**KIRKLEES METROPOLITAN COUNCIL
INVESTMENT & REGENERATION SERVICE**

**DELEGATED DECISION TO DETERMINE PLANNING APPLICATIONS TO
CARRY OUT DEVELOPMENT WITHOUT COMPLIANCE WITH PLANNING
CONDITIONS PREVIOUSLY ATTACHED**

Reference No:	2024/70/90472/W
Site Address:	4, Deer Hill Close, Marsden, Huddersfield, HD7 6LG
Description:	Variation condition 4 (integral garage) on previous permission 2023/92736 for erection of side and rear extensions with associated alterations
Recommending Officer:	Tom Hunt

Officer Report

Block Plan
1 : 500

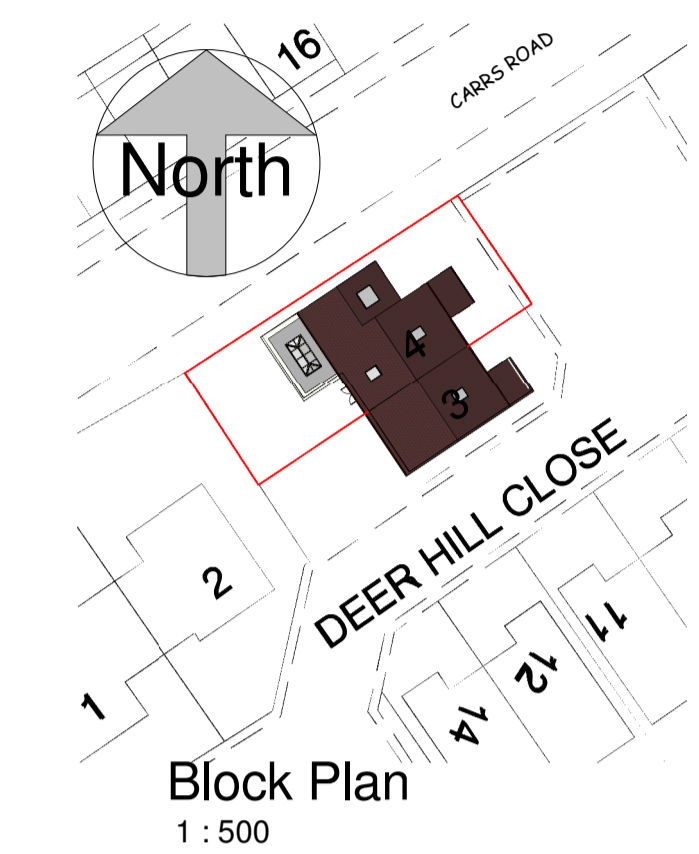
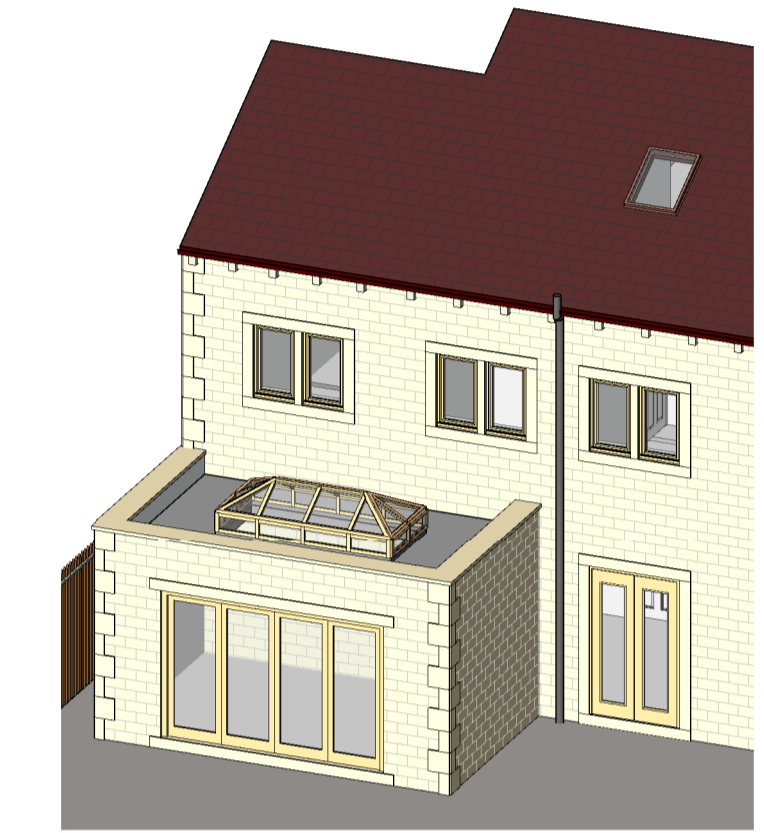
The submitted plans detail an area of soft landscaping would be lost to accommodate a further parking space within the front amenity space. This would see the entire frontage of the site devoted to vehicular parking.

It is considered that to lose the parking provision to the property would lead to the loss of the area of soft landscaped amenity space to the front and a parking dominated frontage. The site is within a prominent location, and the overall character of the street within which the property is sited is that of dwellings with integral garage spaces. It is considered the proposal, to lost parking provision within the integral garage, which forms part of the original design ethos of the street would lead to compensatory parking within the front

On plans for the original permission 2023/92736 and the current application 2024/90472, an additional off street parking space is offered to the front of the property. The delegated report 2023/92736 was silent on this arrangement. The property has the ability to hard surface its front amenity space without planning permission subject to being drained appropriately to ensure no detrimental impact on drainage locally through surface water run off. It is noted that it is already partially hard surface with a mix of surface treatments. In consideration of this, removing the garage as a parking space would lead to further use of this additional space in conjunction with the existing driveway space. The position of this space would appear contrived, overly close to the porch and adjacent to the driveway; should a vehicle be parked within this tight remaining front amenity space, this would necessitate complicated manoeuvring to park two vehicles within and would have greater encroachment on the neighbouring property's front amenity space and the highway through those manoeuvres.

As such, Officers are unable to support this additional space as a feasible alternative off street parking space to the garage and do not consider this as a viable option to compensate for the existing garage's loss of off street parking within the small plot in a high density residential close. The Close does not have kerbside parking or pavements but has residential properties with driveways and garages which substantially limit on street parking arrangements.

Ground Floor Plan
1 : 100

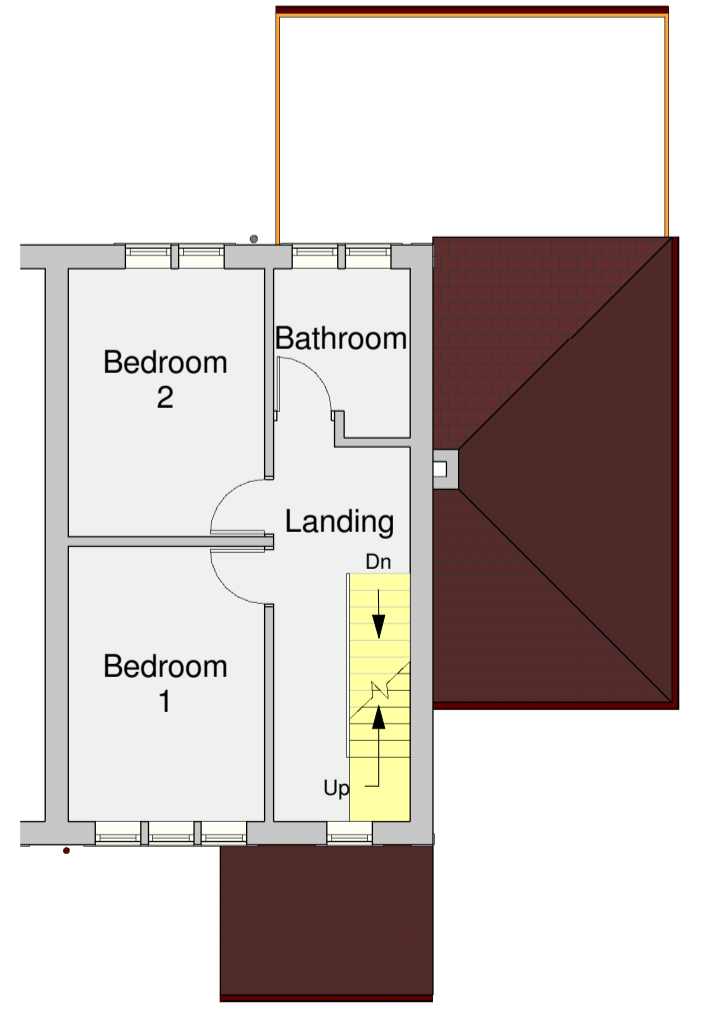
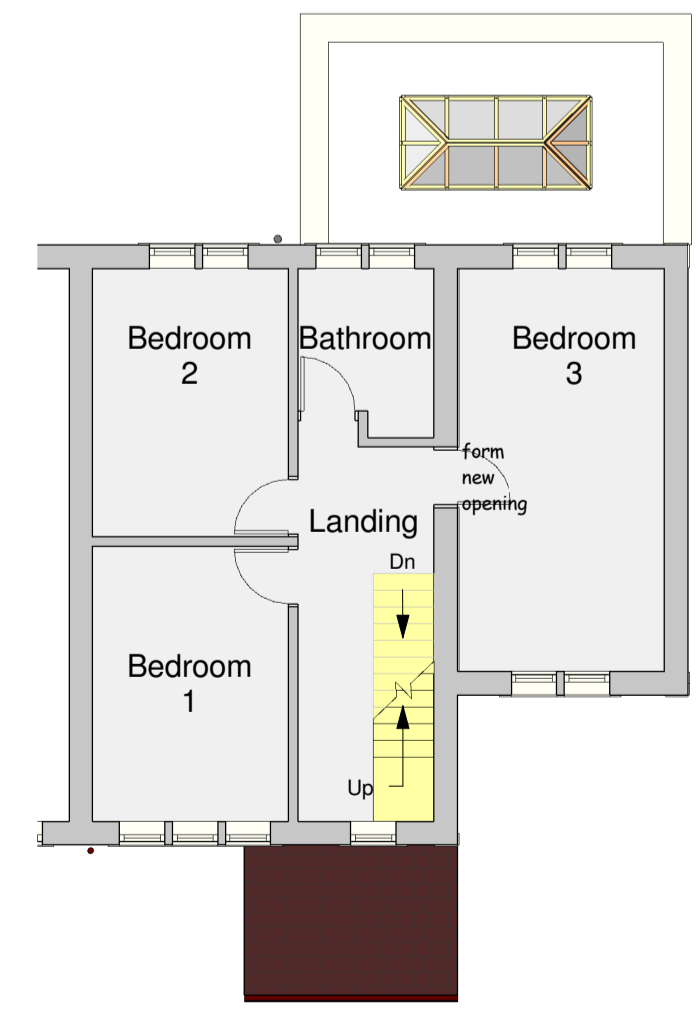
Officer Note: The general study is not considered a material consideration that can be afforded significant weight in this case. For clarity, the integral garage has internal space dimensions of 5.5m depth and 2.75m width compared to the recommended standard minimum 6m depth by 3m width for modern vehicles in the Kirklees Highways Design Guide SPD. As such, the modestly under-specified dimensions of the integral parking space still have the potential to provide adequate garaging space for some vehicles.

- 2) Addressed in point 1 above.
- 3) The garage space is used for storage and white goods presently.
Officer Note: this is not set out in the existing plans and Officers can only assess based on submitted plans. In addition, Permitted Development Rights are removed under application 2002/91929 as below:
“(3) The garage or parking space intended to serve the dwellings shall be provided and the parking spaces shall be drained, sealed and surfaced in accordance with details to be approved by the Local Planning Authority before the dwellings are occupied and shall not thereafter be used for any purpose other than parking and turning of vehicles.”
Planning Permission is therefore required for the use as set out.

- 6) It is asserted that the property would remain a three bedroom property.
Officer Note: Plans indicate that an additional bedroom would be added and have been assessed as such. It is noted that the side extension would also offer an additional office of a substantial size similar to a new proposed bedroom, which could be converted to a bedroom easily without planning permission.
